## Planning & Environment

Contact: Megan Fu  
Phone: 02 9228 6531  
Fax: 02 9228 6540  
Email: [megan.fu@planning.nsw.gov.au](mailto:megan.fu@planning.nsw.gov.au)  
Our ref: SSD 6339

### **St Catherine's School Master Plan (SSD 6339) Response to Submissions**

## **ATTACHMENT A: KEY ISSUES**

Residential Flat Building at
No.4 Macpherson Street
Plans

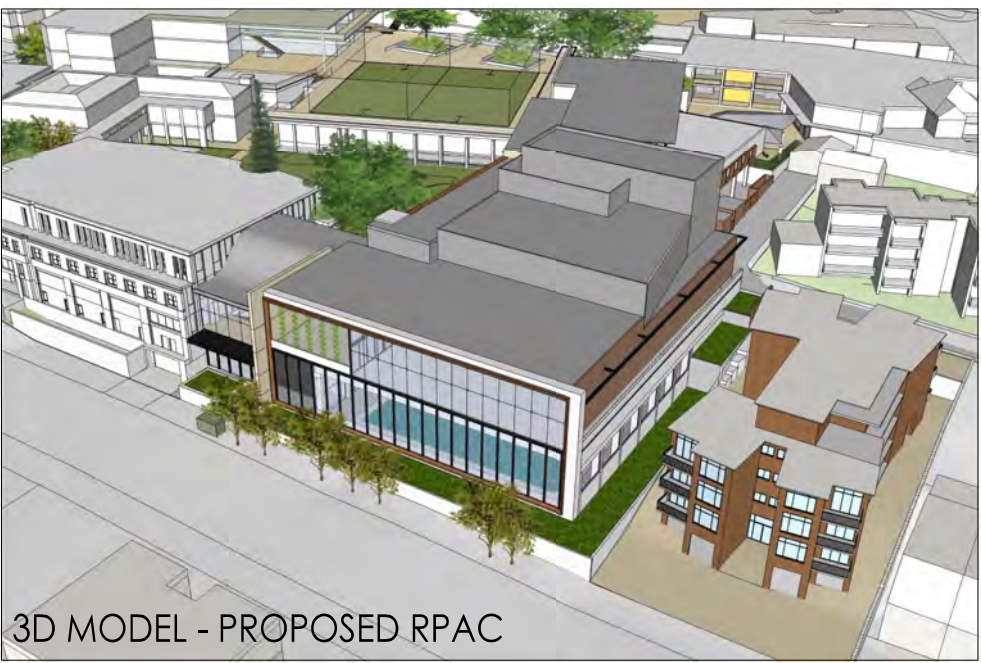
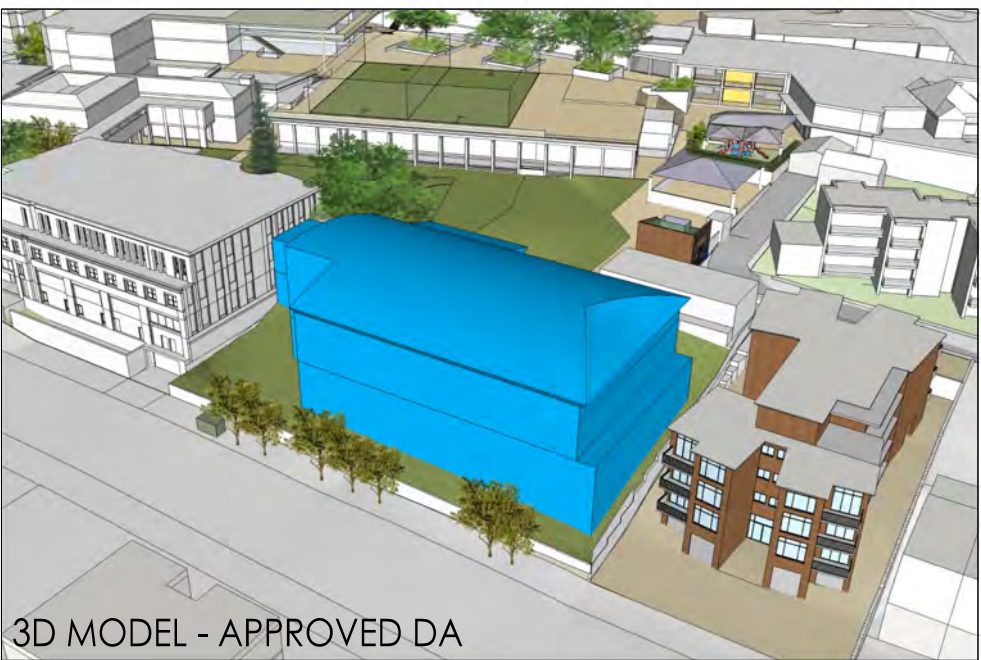
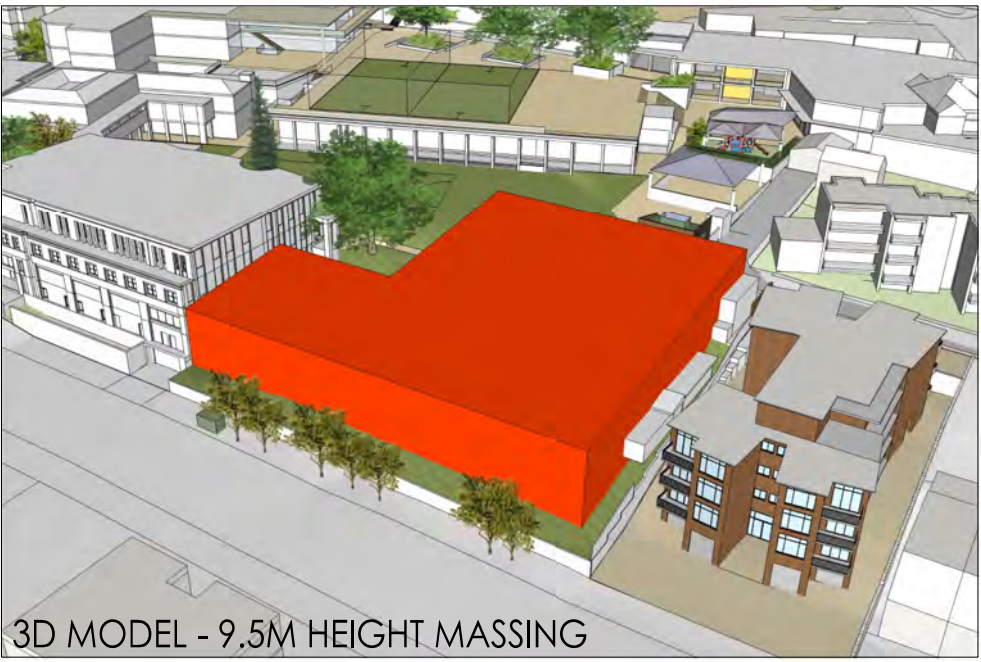
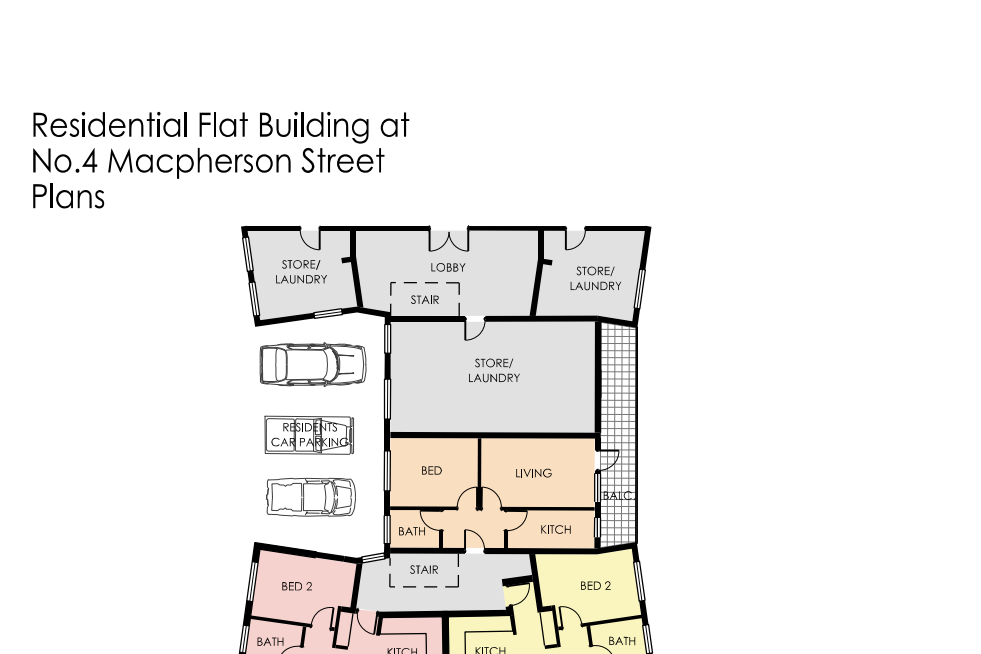
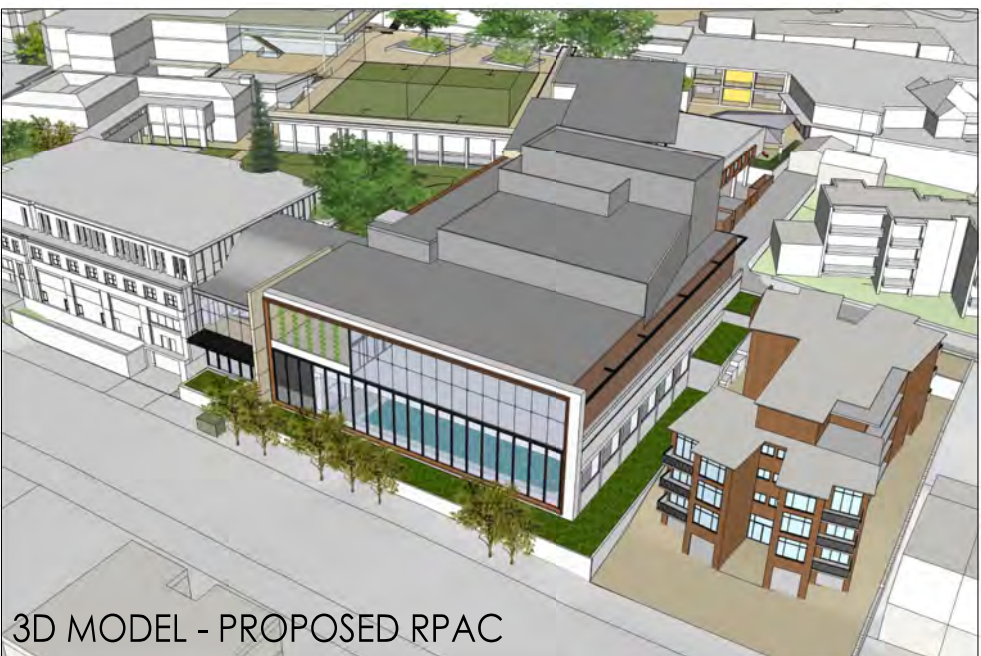
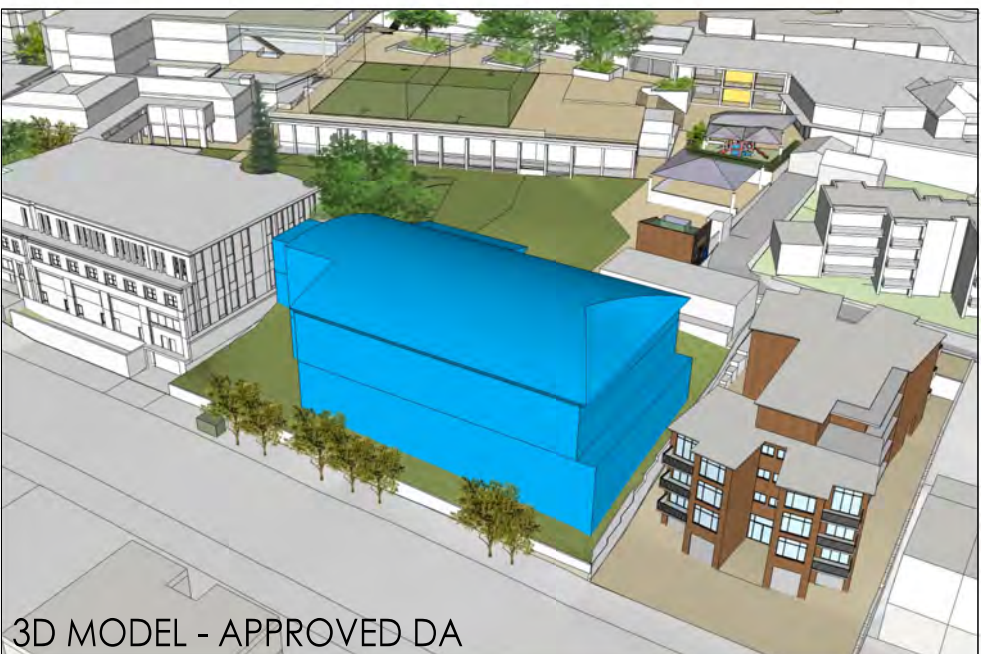
6. Provide elevation shadow diagrams clearly illustrating the existing and proposed level of solar access to north facing properties of 4 Macpherson Street at 30 minute intervals between 9 am and 3 pm during mid-winter.
7. Review the project specific noise operational noise criteria established for the Leichhardt Lane residences as the amenity criterion has been adopted which is higher than the amenity criterion.
